WEST SUSSEX COUNTY COUNCIL CONSULTATION

TO:	Arun District Council FAO: Simon Davis
FROM:	WSCC - Highways Authority
DATE:	1 September 2020
LOCATION:	The Former Ship Inn Aldwick Street Aldwick PO21 3AP
SUBJECT:	AW/197/20/PL Variation of conditions 8-concerning hours of deliveries & 10 types of vehicles making deliveries following AW/211/14/PL. This application is in CIL Zone 4 (Zero Rated) as 'other development'.
DATE OF SITE VISIT:	n/a
RECOMMENDATION:	No Objection
S106 CONTRIBUTION TOTAL:	n/a / £ See below for breakdown.

Client
Surplus Property Investments
Project
The Former Ship Inn, Aldwick Street, Bognor Regis. PO21 3AP
Title
Vehicle Tracking : Cars Passing Delivery Vehicles
Scale
1:500 @ A1
Date
21.07.2020
Drawn By
PAL
Checked By
PM
Project No:
B200038
Drawing No:
B 204
Revision
-

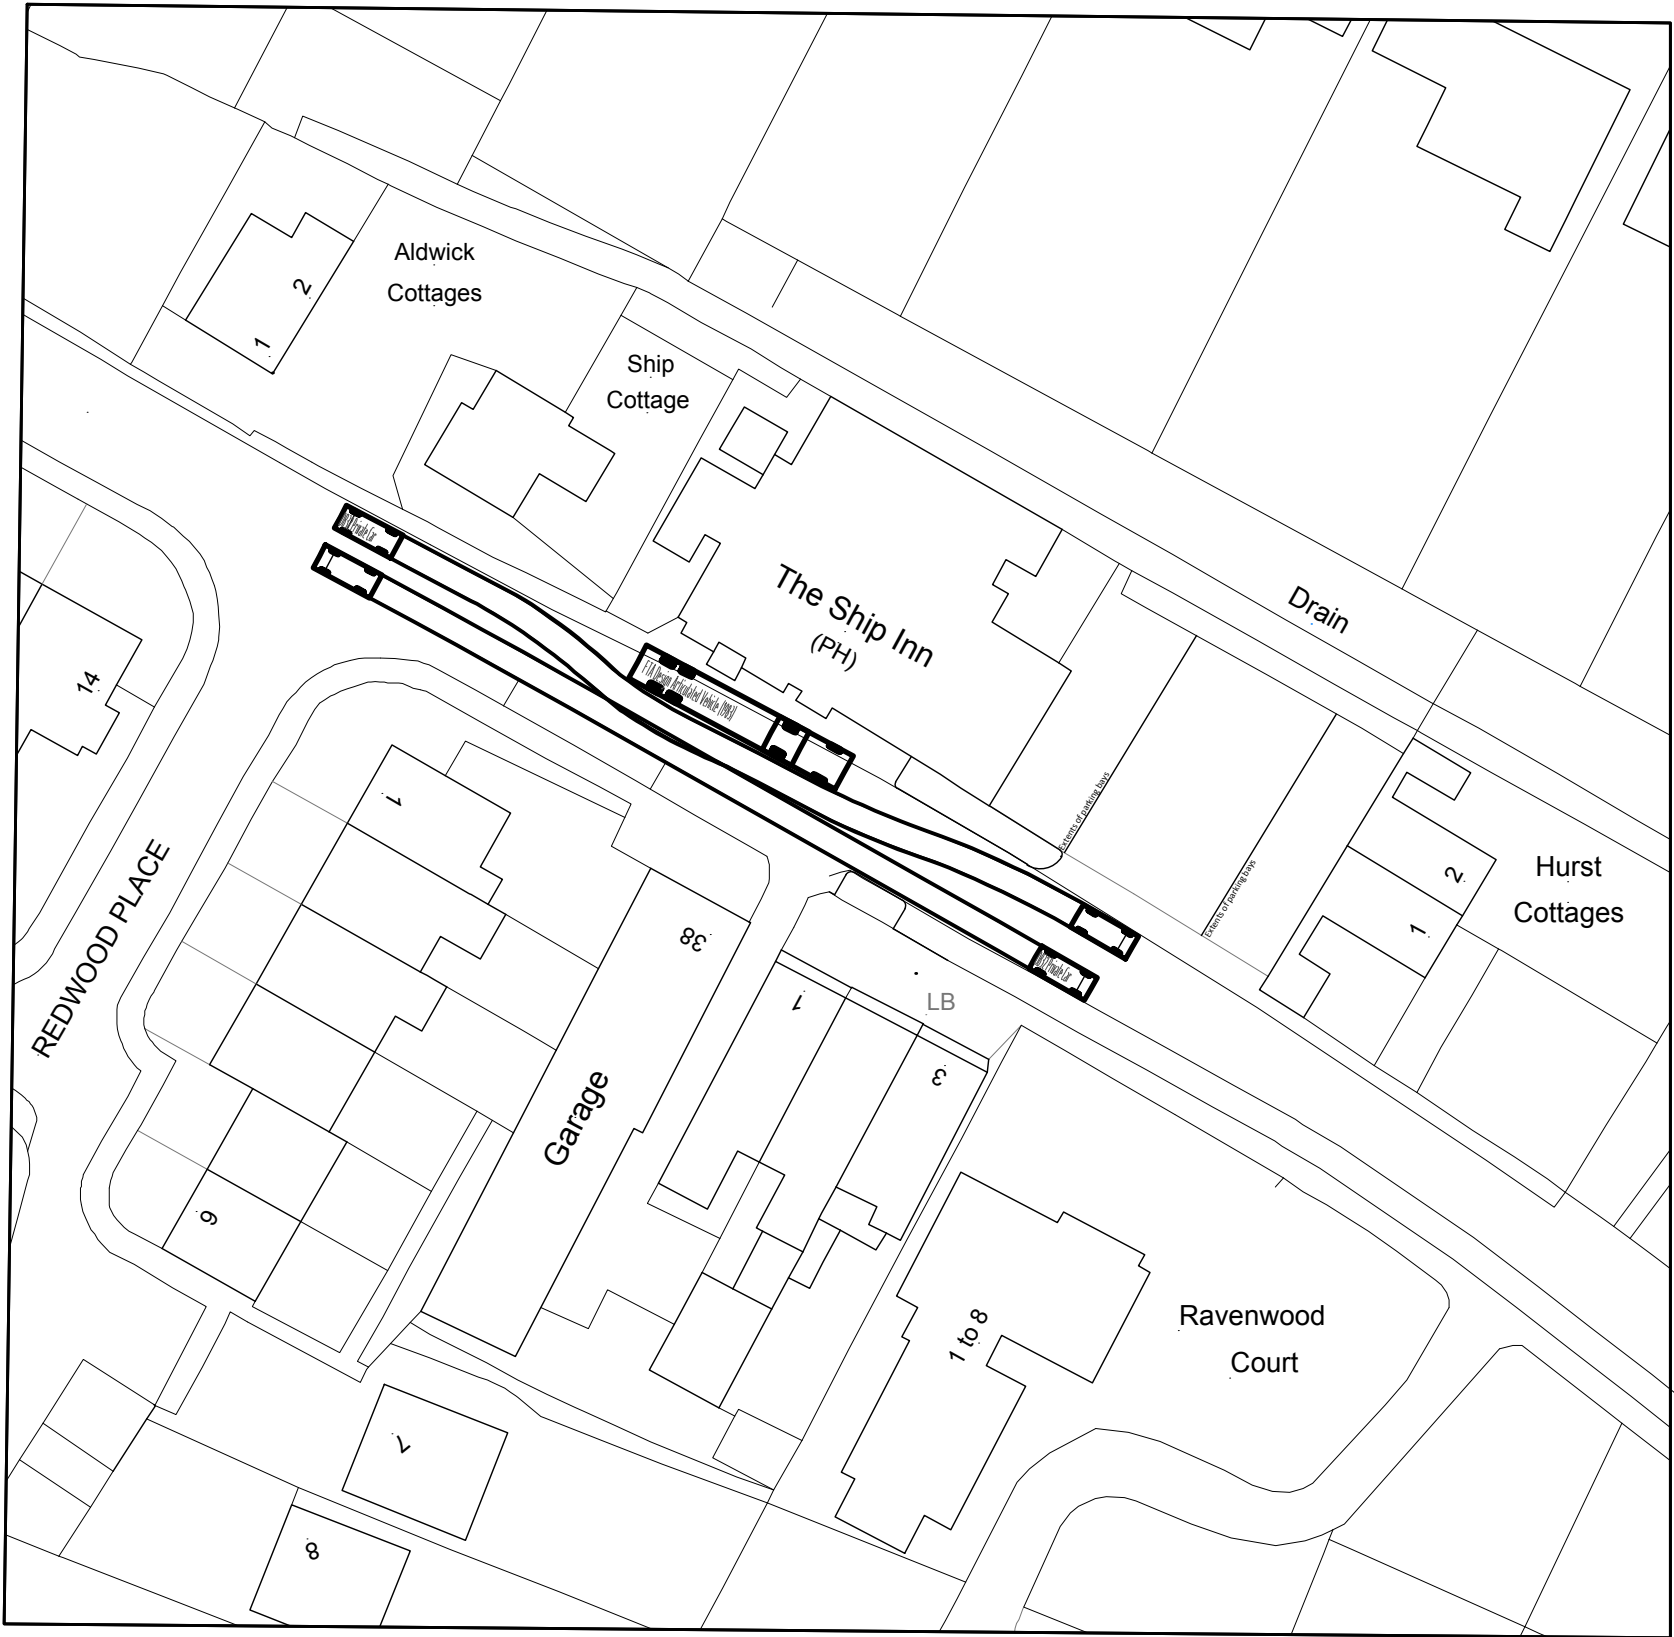
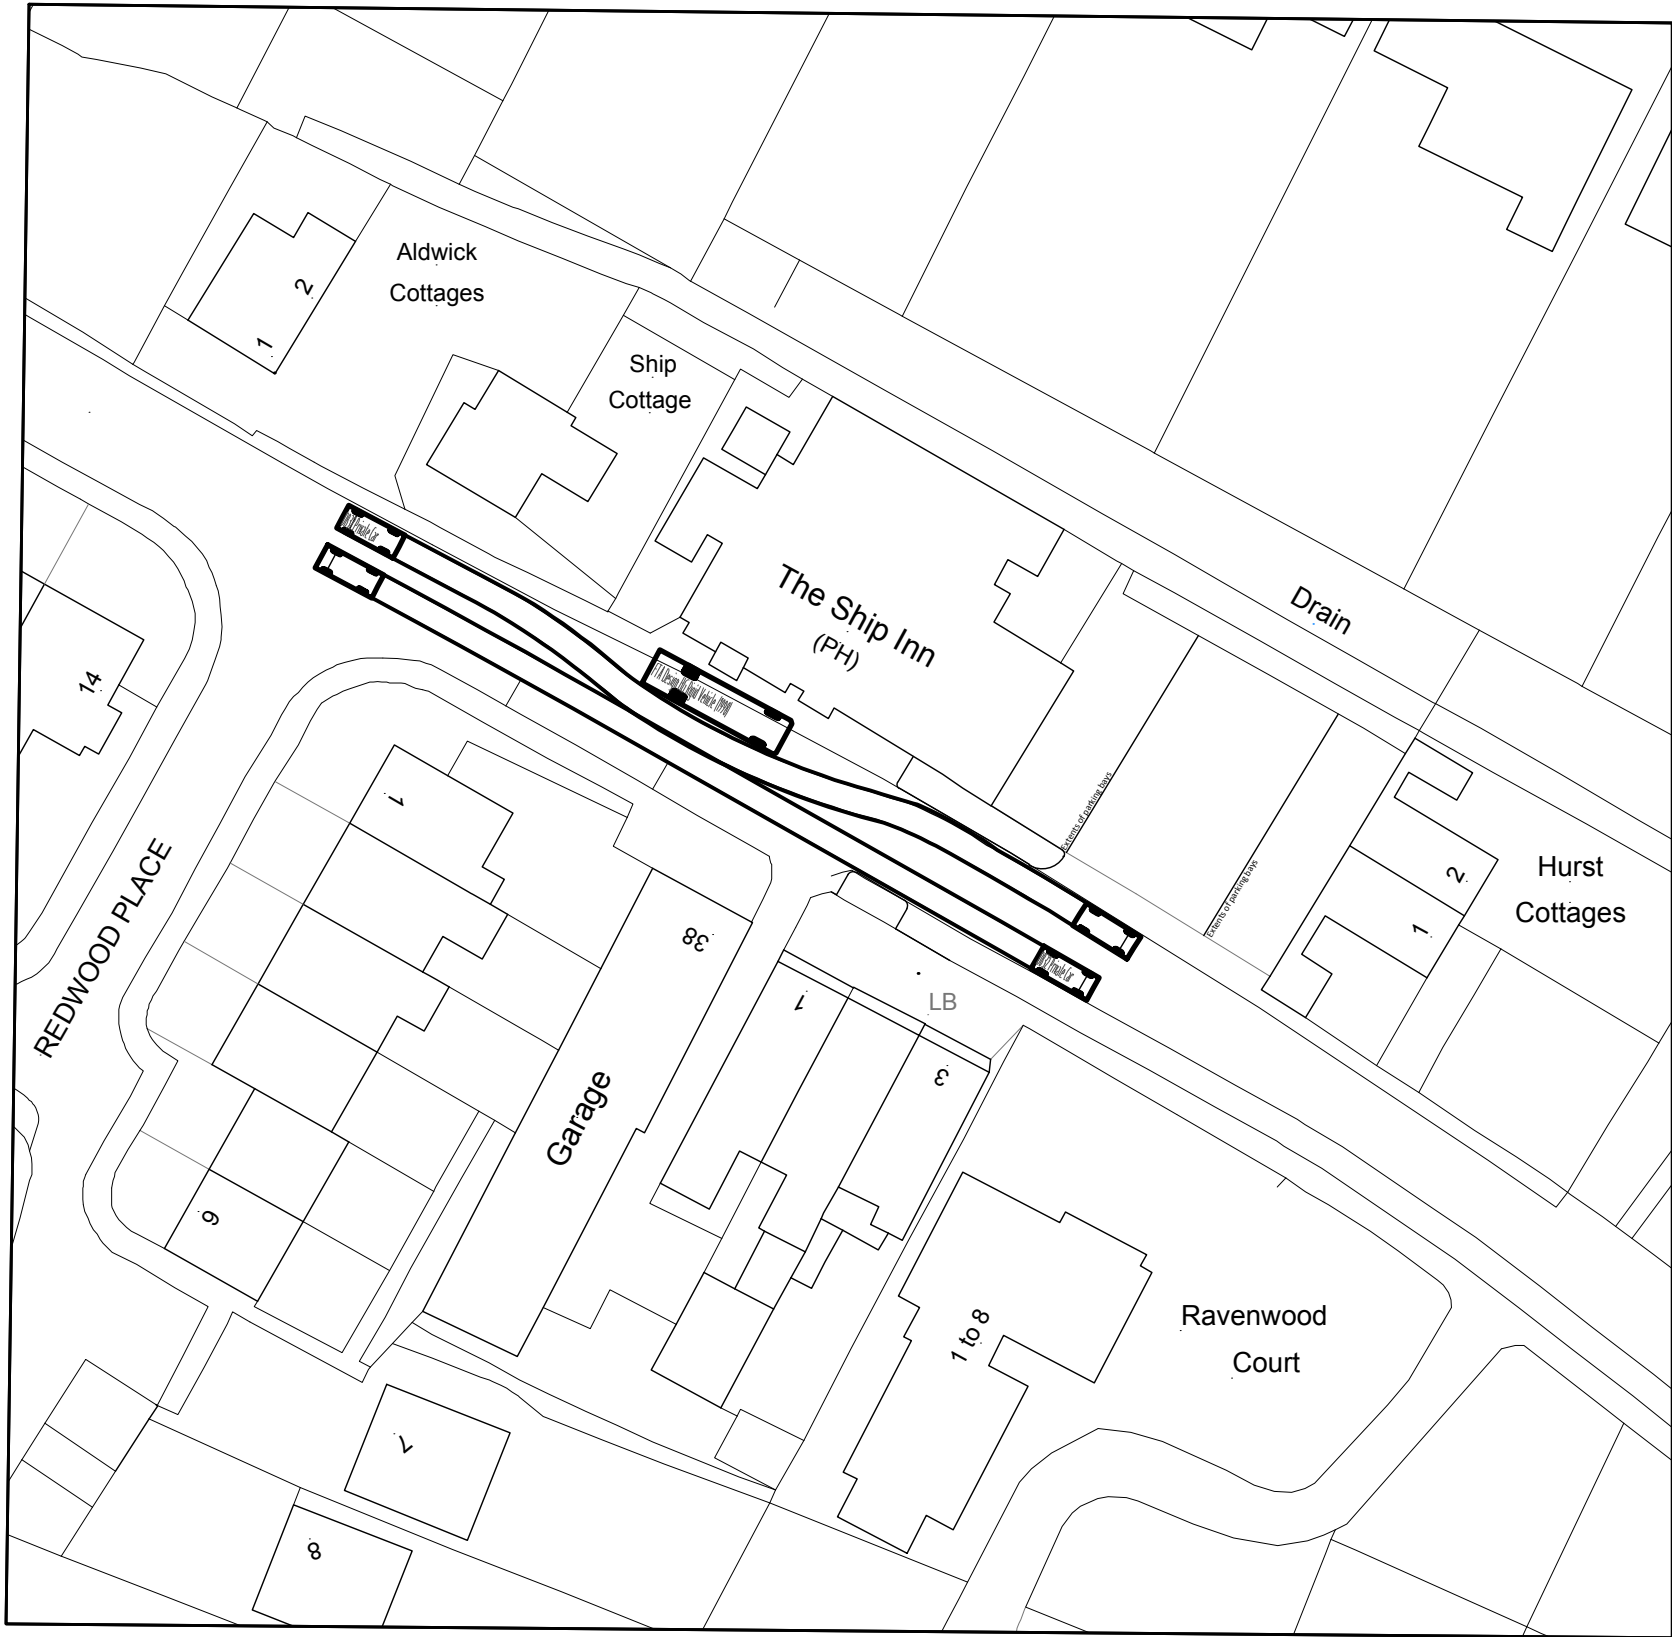
Swept path diagrams show a combination of movements and vehicle types to demonstrate a rigid vehicle, or articulated vehicle can load and unload in the highway without causing any significant harm to the operation of the highway network.
